From: Daun Johnson <[REDACTED]> on behalf of Planning.Responses
Sent: 26 October 2018 09:17
To: Sian Eggington
Subject: FW: Further Information Required on Your Ref: PP-07370202 Our Ref: R/248/18/HH
Attachments: 8 Ex and proposed front access plan.pdf; 9 Ex and prop access elevations.pdf; 12 Block Plan.pdf; 11 Location Plan.pdf; 10 Site Plan.pdf

Re application above. I have noted your comments and hope that I have rectified all to your satisfaction.

Drawing Ref.: SG/04/Sou12

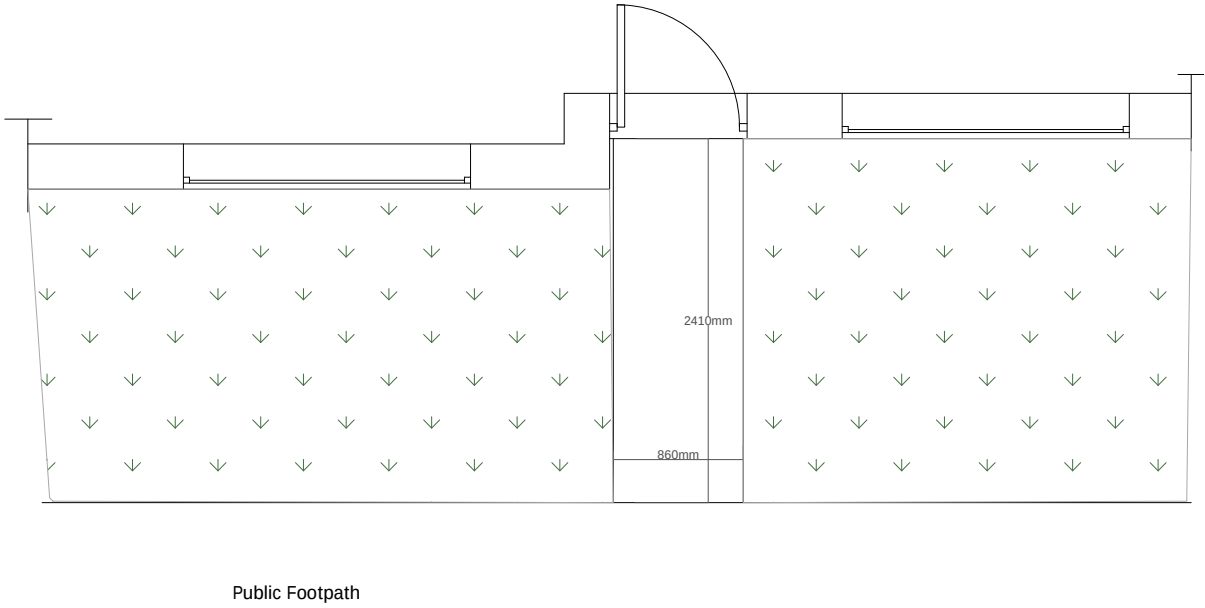
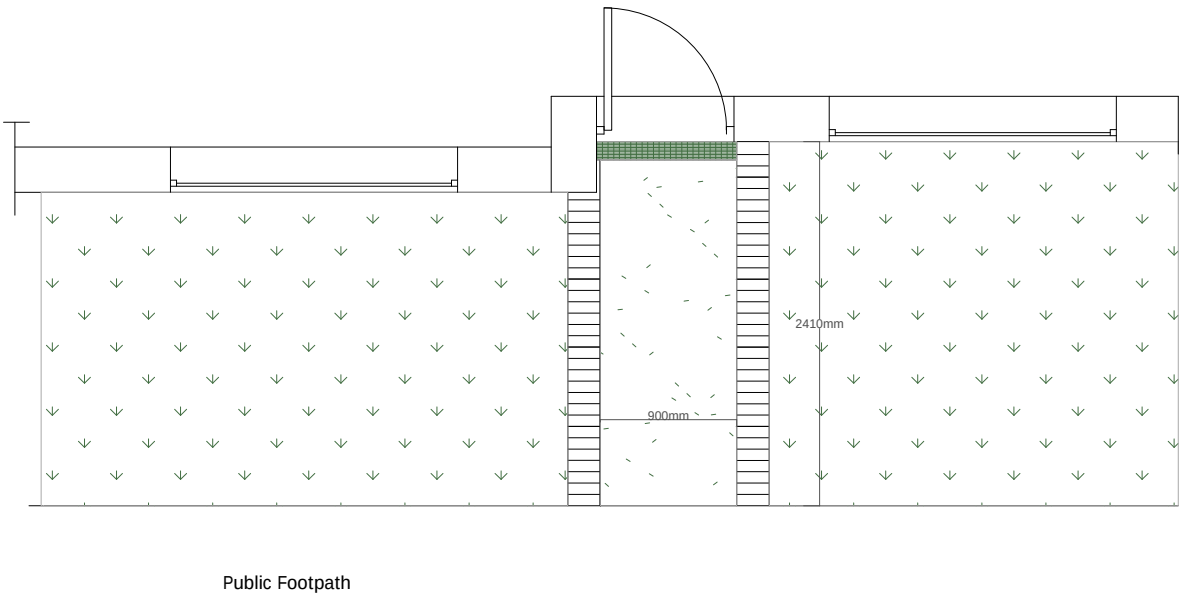
SG/04/Sou12 – Scale corrected to 1:50

Dimensions - Length of ramp added on SG/04/Sou12
Height of side upstands added on SG/01/Sou12
